H2Teesside Project

Document Reference: 9.7: Statement of Common Ground between H2 Teesside Limited and Natural England

Date: September 2024

**Statement of Common Ground between the H2 Teesside Limited and
Natural England**

# AECOM

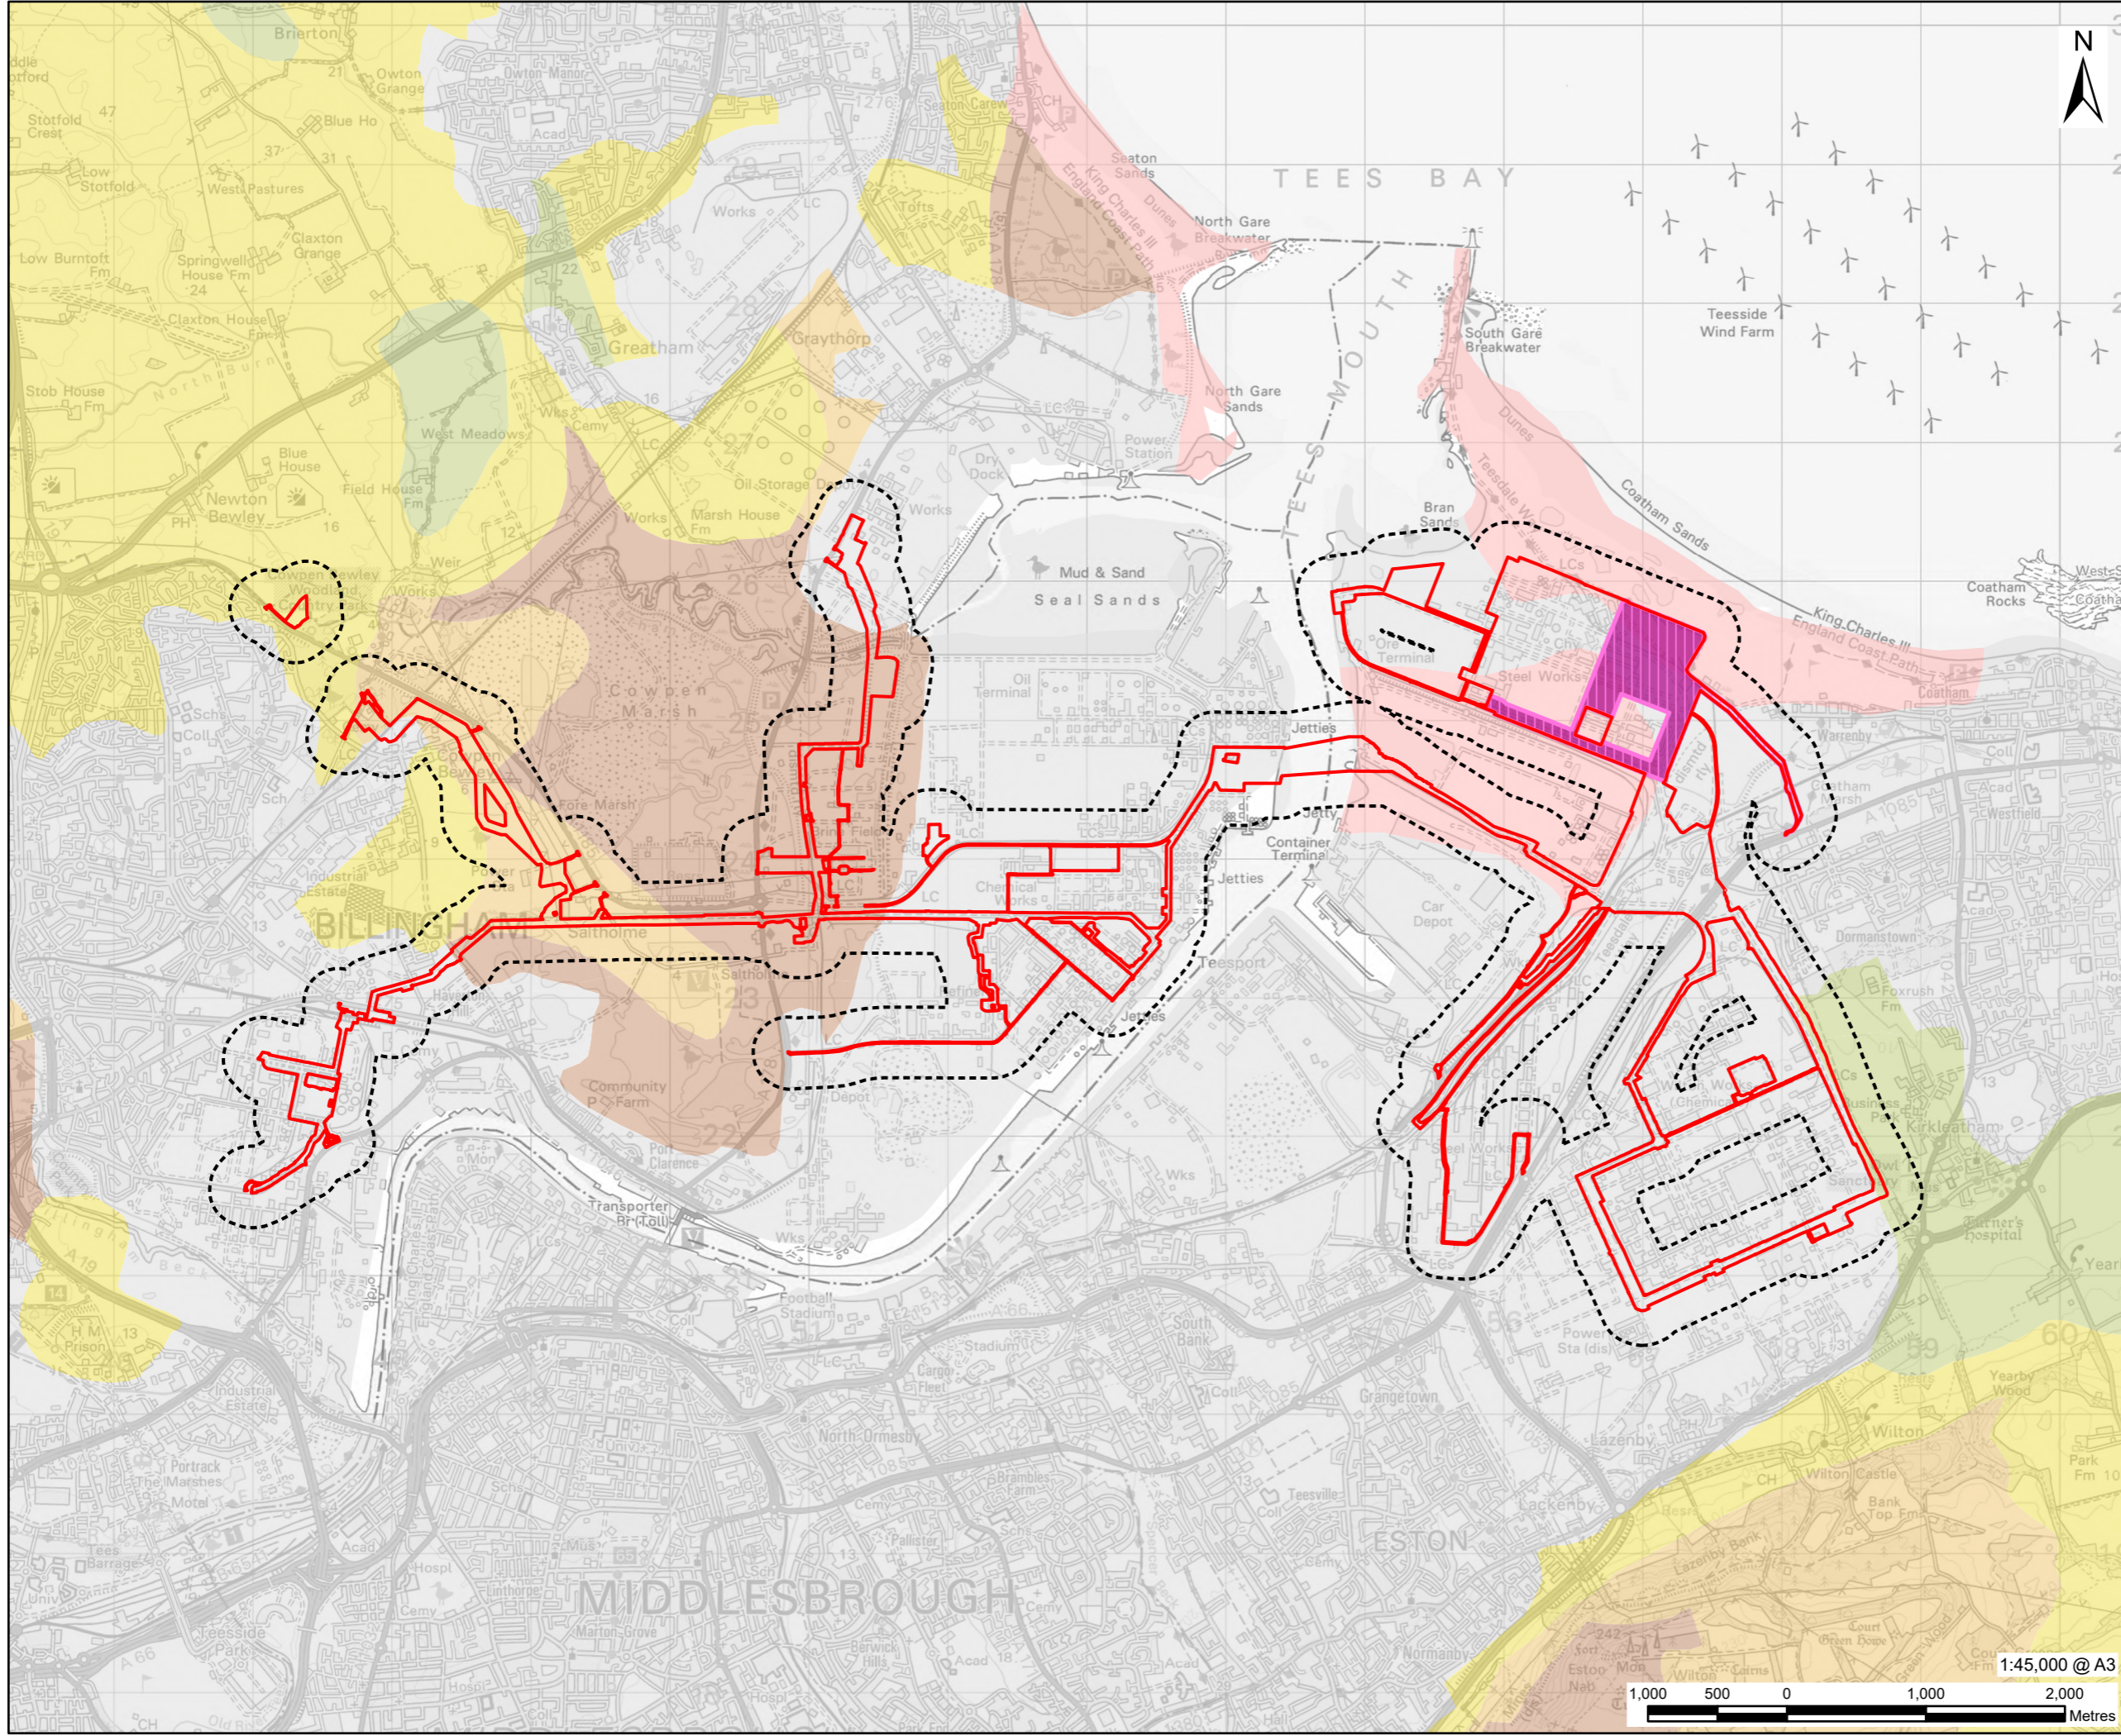
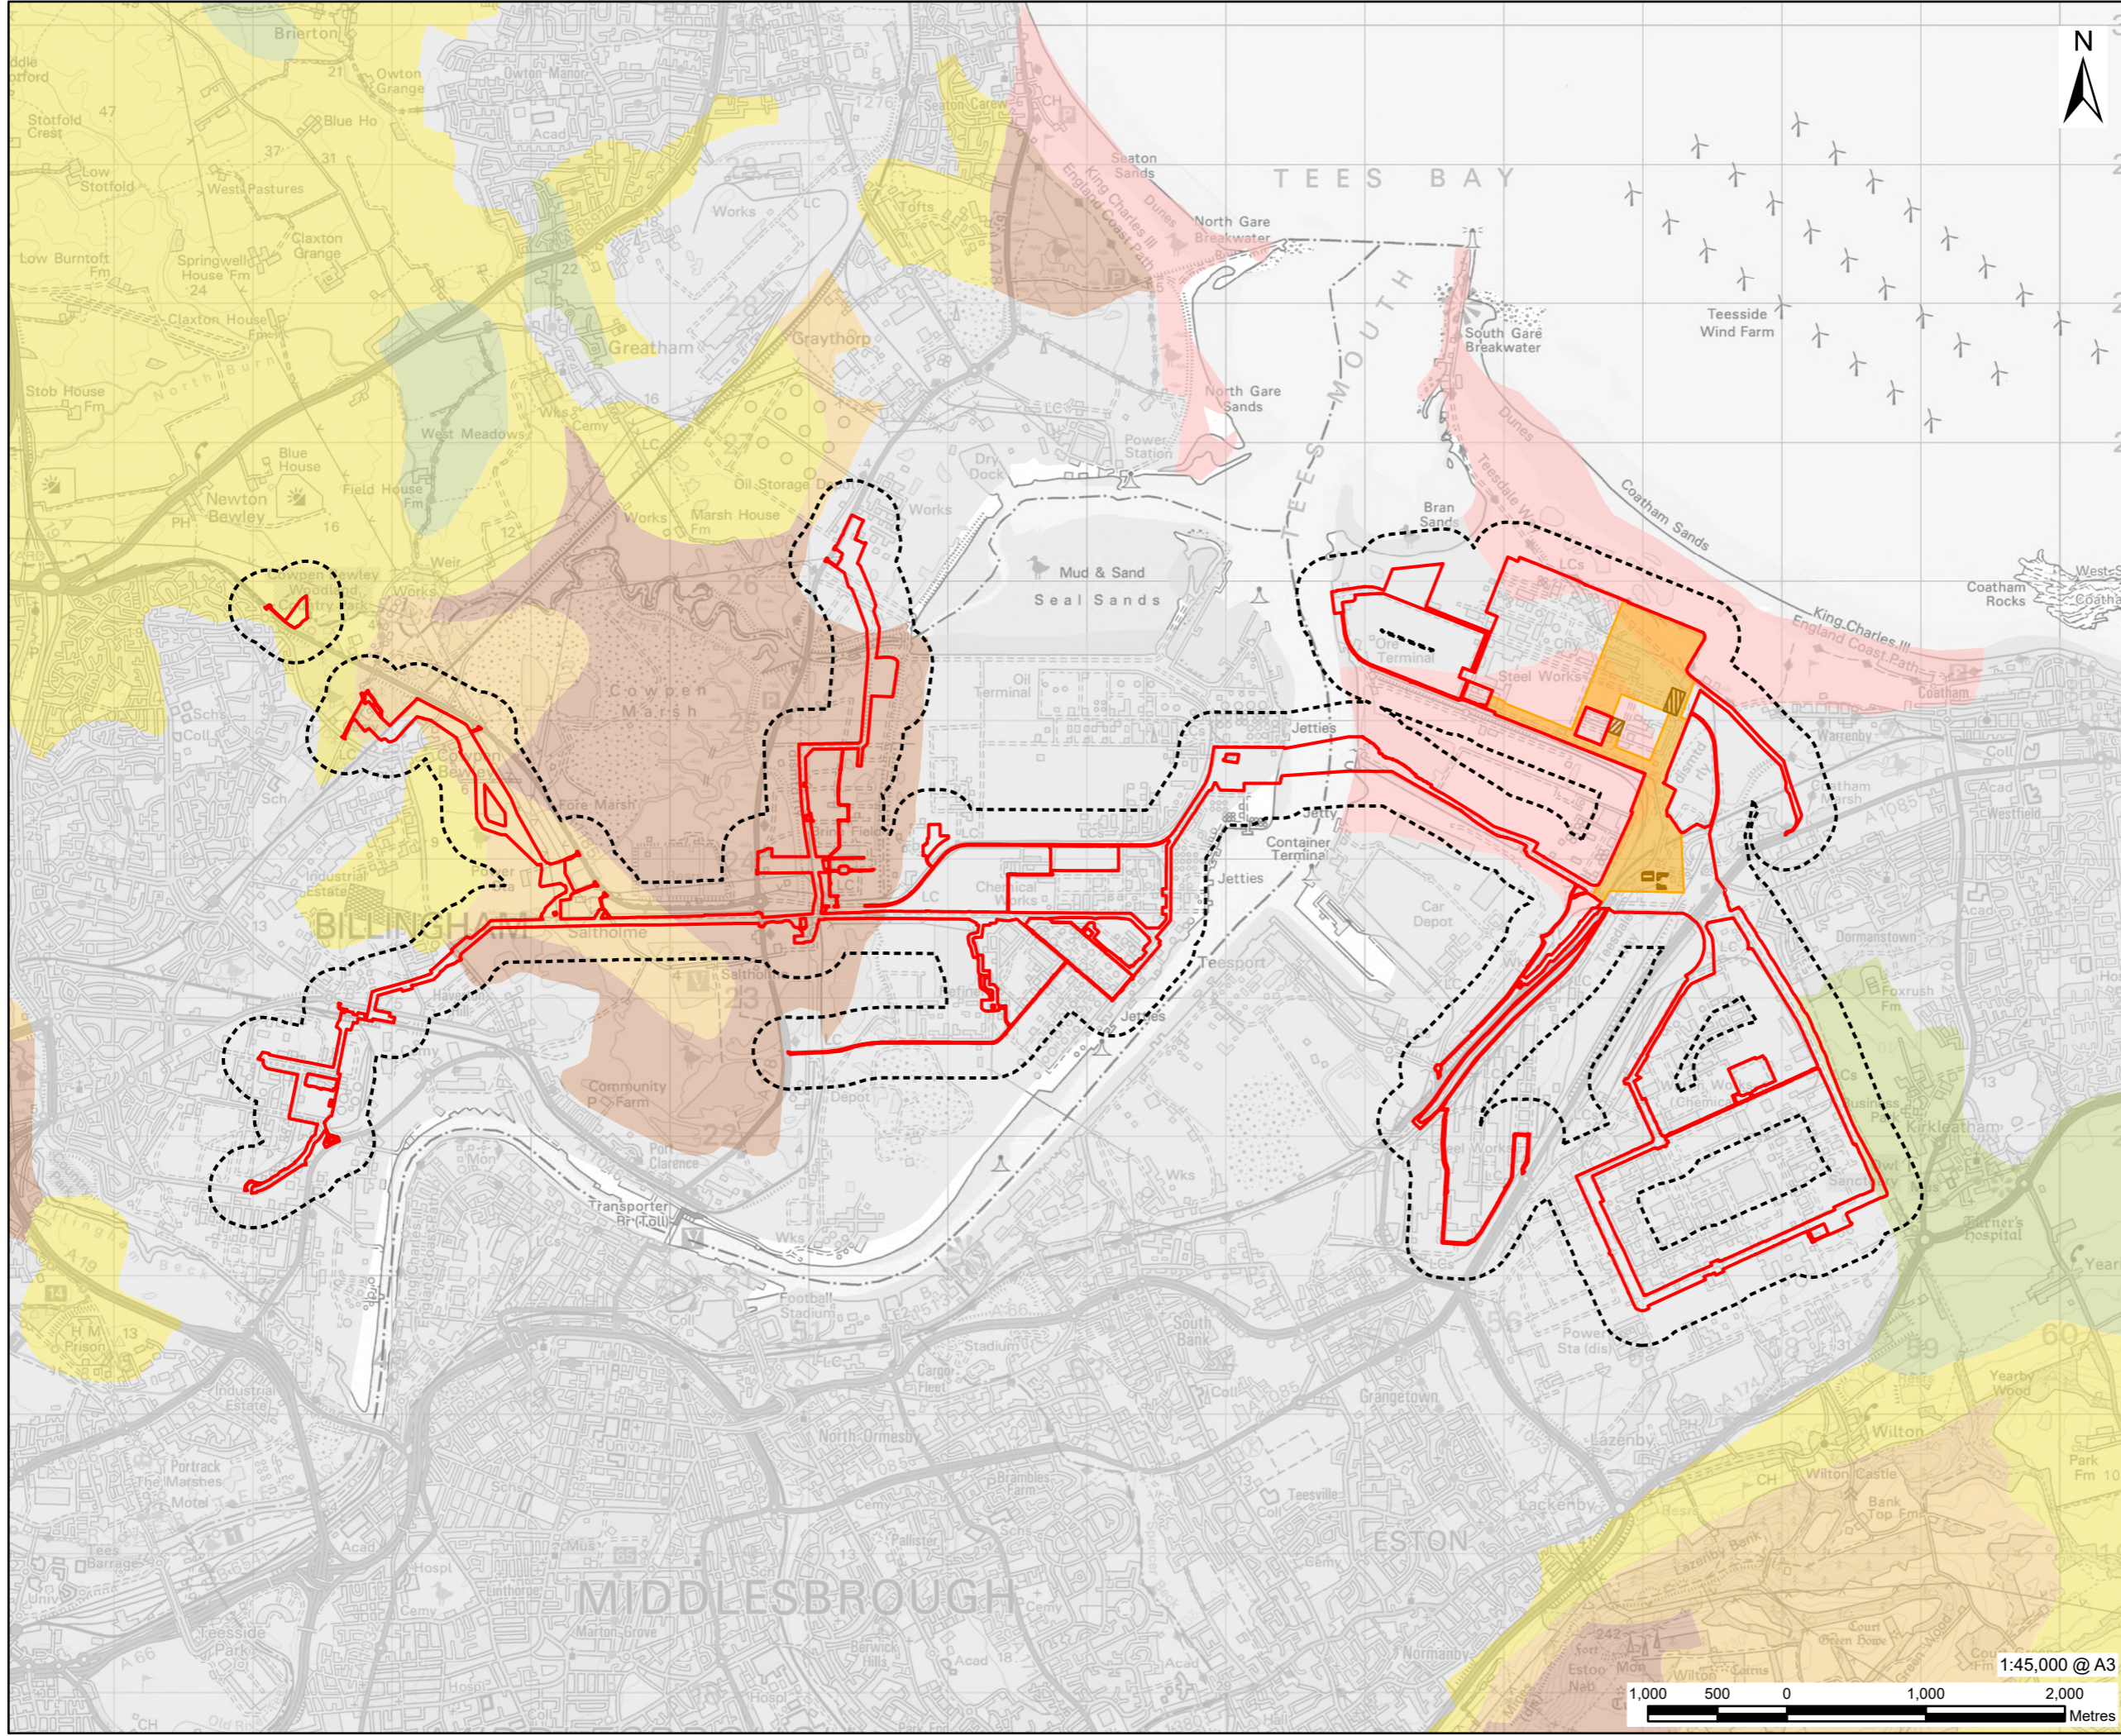
11.	Best and Most Versatile Land	<p>BMV land across the Proposed Development Site is limited, with the majority of the Main Site and Connection Corridors classified as Urban and Non-Agricultural. A small portion of the Hydrogen Pipeline Corridor north of the River Tees has land classified as Grade 3, 4 and 5. As a worst case scenario Grade 3 land, at the Cowpen Bewley Replacement Land, is assumed to be Grade 3a, making it BMV land for the purposes of the</p>	<p>NE considers appropriate mitigation to prevent the loss of BMV land, should be set out within the assessment. This would require a detailed ALC survey of the pipeline routes to inform restoration. The following actions should be undertaken:</p> <ul style="list-style-type: none"> • For all areas in which POST-1988 ALC Survey information is not available, an ALC survey should be undertaken. • The colours used for mapping should be updated to match standard ALC colours.

SOCG ID	MATTER	APPLICANT POSITION	NATURAL ENGLAND POSITION
		<p>assessment presented in ES Chapter 10 ‘Geology, Hydrogeology and Contaminated Land’ [APP-062].</p> <p>Taking into account the above, the Applicant does not propose to undertake supplementary ALC surveys of the Proposed Development Site at this time. However, the Applicant recognises the need for careful soil management and handling. The Framework CEMP [APP-043] will be amended to include the production of a Soils Management Plan (‘SMP’), included as part of the Final CEMP, produced prior to construction.</p> <p>ES Figure 10-1 [APP-110] is for artificial geology/made ground only. ES Figure 10-19 [APP-137] will be updated to include the correct colours for each ALC grade at Deadline 2.</p> <p>No further updates are anticipated to be submitted.</p>	<ul style="list-style-type: none"> • The soil information presented (Figure 10-1 [APP-110]), should include the mapped soil associations. • The consideration of soil handling should be expanded in a Soils Management Plan (SMP) (Ref. NE35).
